DECISION DELEGATED TO HEAD OF PLANNING

Application No: H09-0627-25 **Applicant:** Mr H Juniper

Proposal: Proposed extension to dwelling to form bedroom and en suite above former garage

Location: 28 Balmoral Way Holbeach Spalding

SCALE 1:50
SCALE 1:1

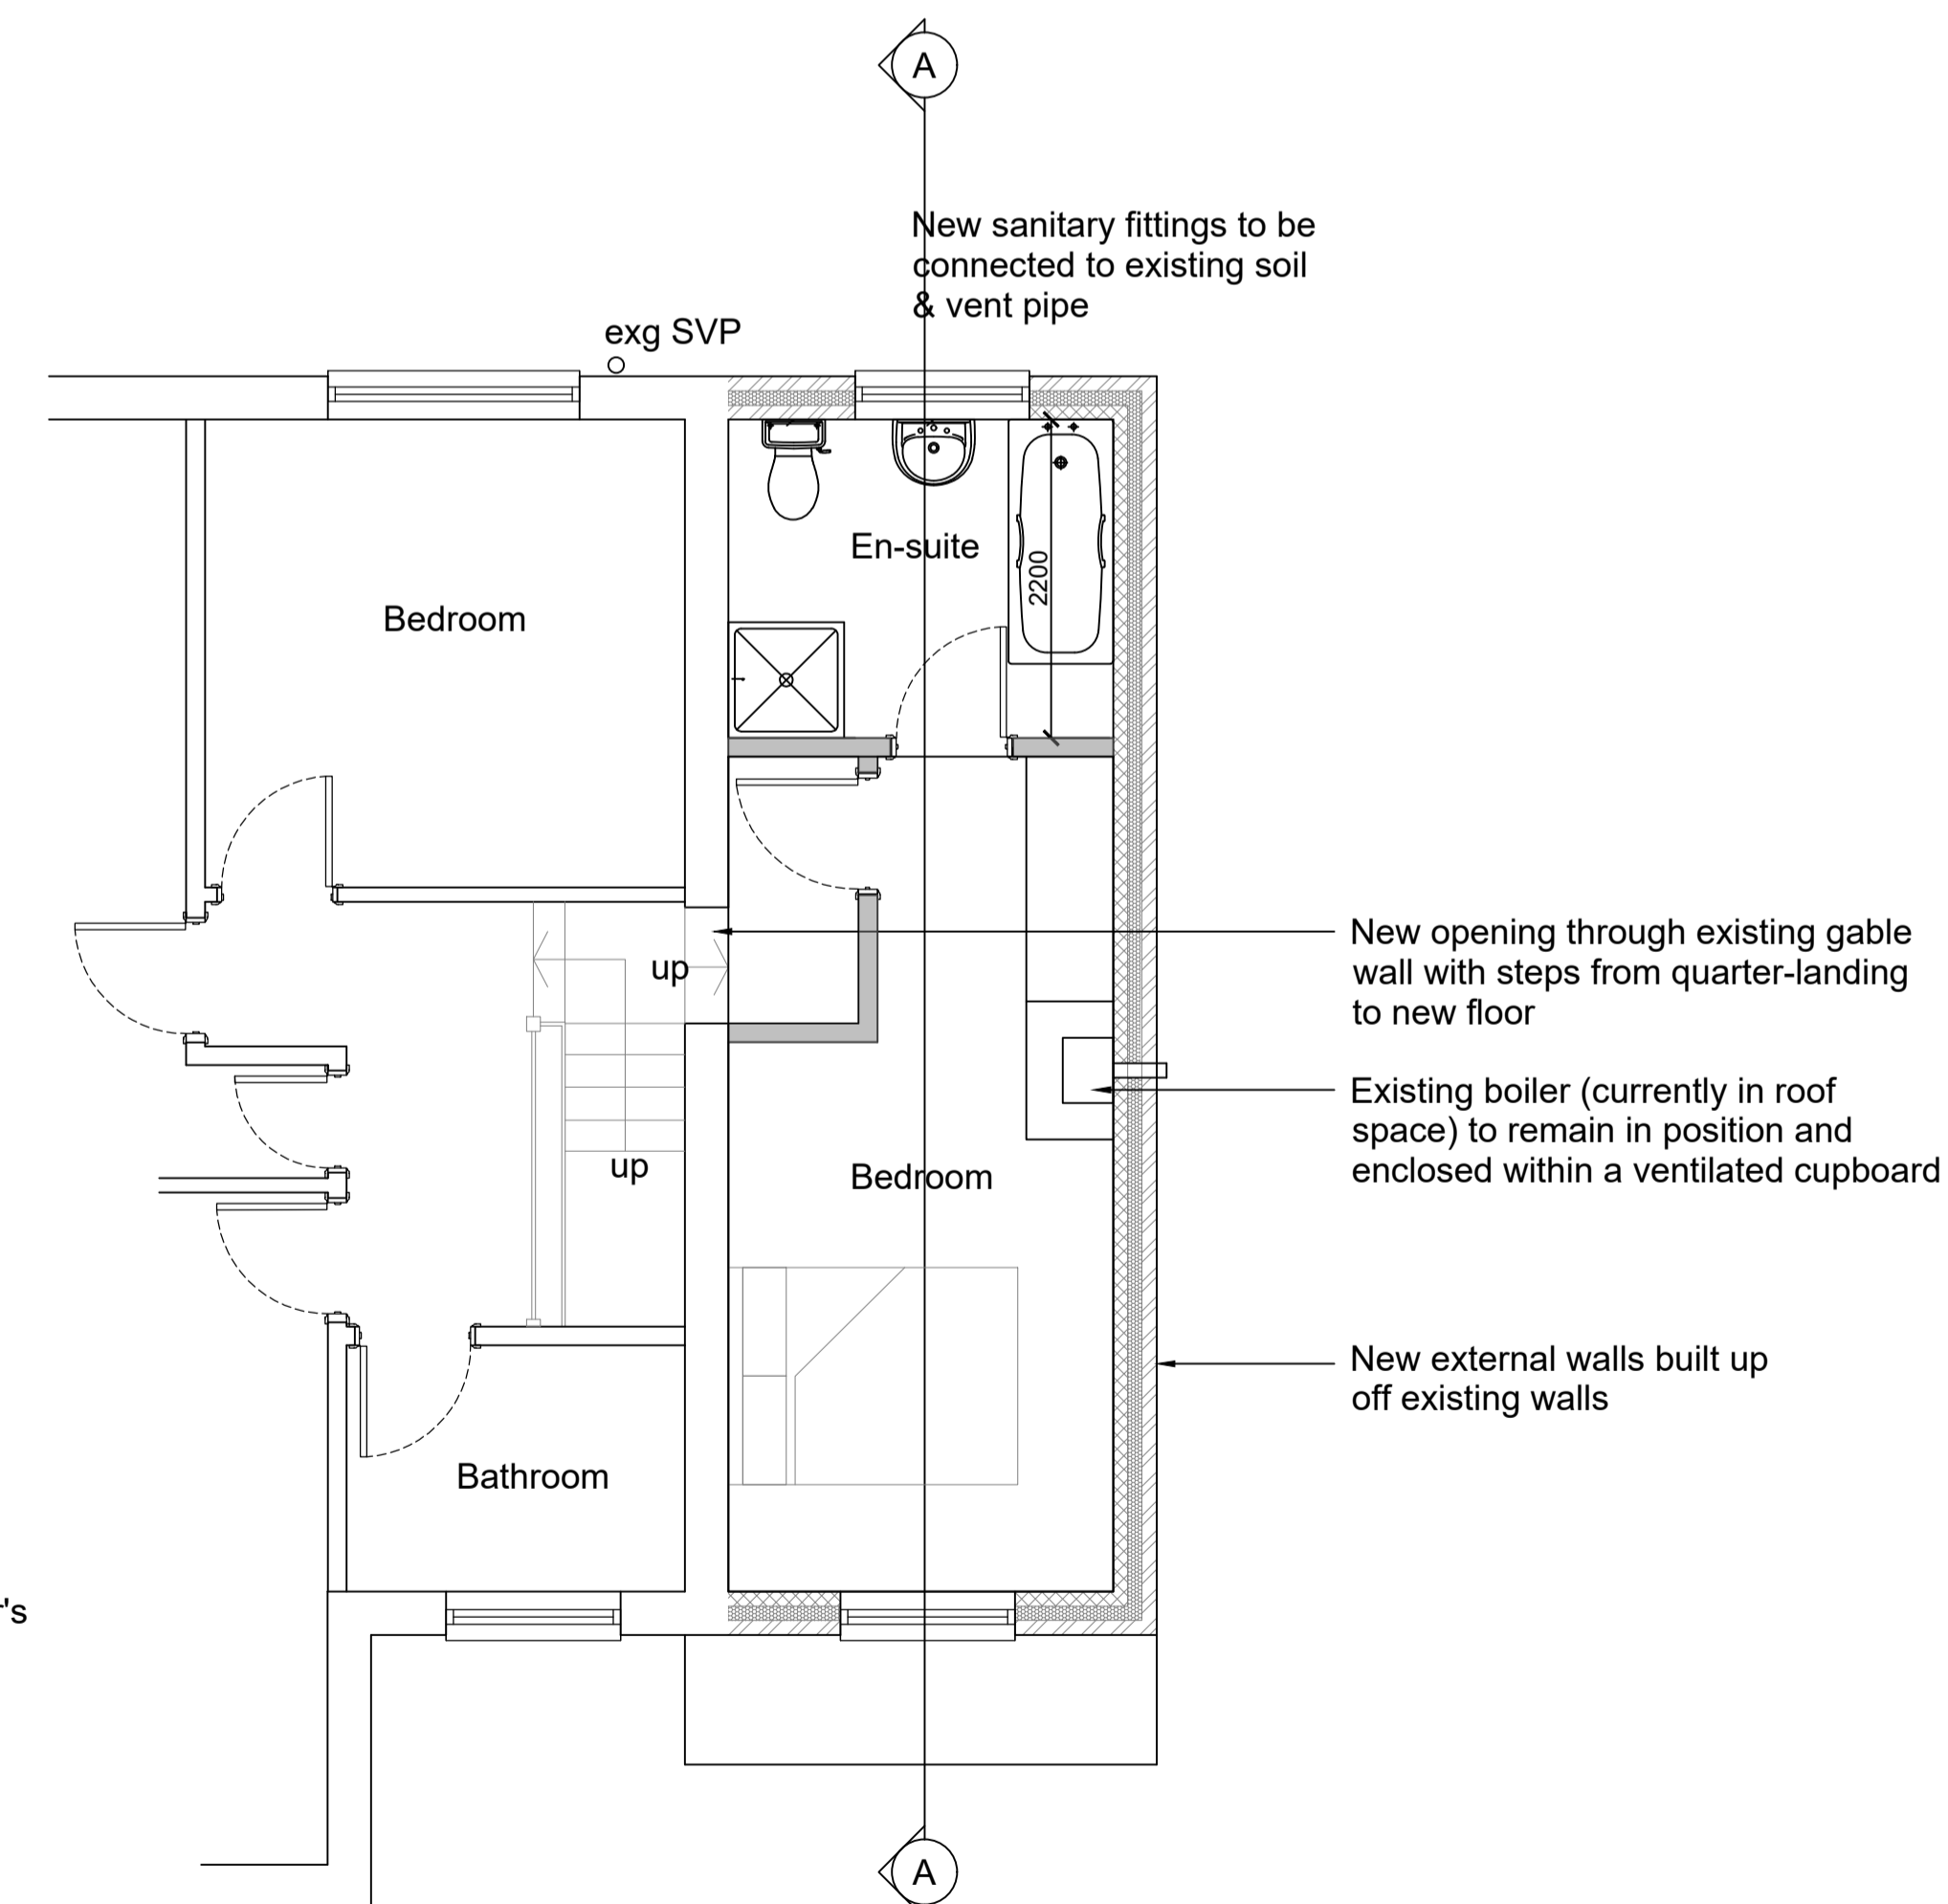
The extension would be constructed from existing materials throughout and would match the host dwelling. The extension would protrude from the side by 2900mm and would run the entire length of the main house, sitting at 8700mm. It would be level to the eaves and ridge of the host dwelling; being 5000mm and 8400mm respectively.

The proposed extension would project to the side of the host dwelling at first floor level, providing an additional bedroom and en-suite. The extension would project above the existing ground floor accommodation, which serves as a garage. The proposed extension would therefore sit on the same floor area as the ground floor section.

As the materials would also match throughout, this would ensure that the extension would remain in keeping and thus acceptable in this regard. Whilst the extension is not subservient, given that it would be level to the ridge height of the existing dwelling, this is not considered to be a significant enough issue to warrant a refusal.

The window proposed to the front, serving the proposed additional bedroom, would be acceptable in this instance. Despite facing other existing dwellings, it would be not form a notably different outlook in terms of impact, to that of the other windows across this elevation. In a similar light, the window to the rear would be obscure glazed due to it being for an en-suite. This would be conditioned to ensure that it remains this way and that there is no impact to the amenity of residents through overlooking.

Due to the positioning of the site, this ensures that the only shadow that could be cast would be to the direct neighbour for No. 28. However, this would be at the latest point in the day when the sun is setting. Notwithstanding this, as the extension would be to the same height as the host property, there would be no significant increase in detrimental harm. As such, no overshadowing impact is considered to be raised.

Whilst the floor plan does not show the whole property, it can be assumed from the size of the dwelling that there would be at least three dwellings on the first floor. The side extension seeks to create an additional bedroom and therefore takes the number up to four. As a result, there must be at least three vehicle parking spaces to accommodate this and meet the standards set out in Appendix 6. The driveway to the front of the site could support up to three vehicles and whilst a garage door is featured on the front elevation it should be noted that this has already been converted. Therefore, it accords to Appendix 6 and provides enough vehicle parking.
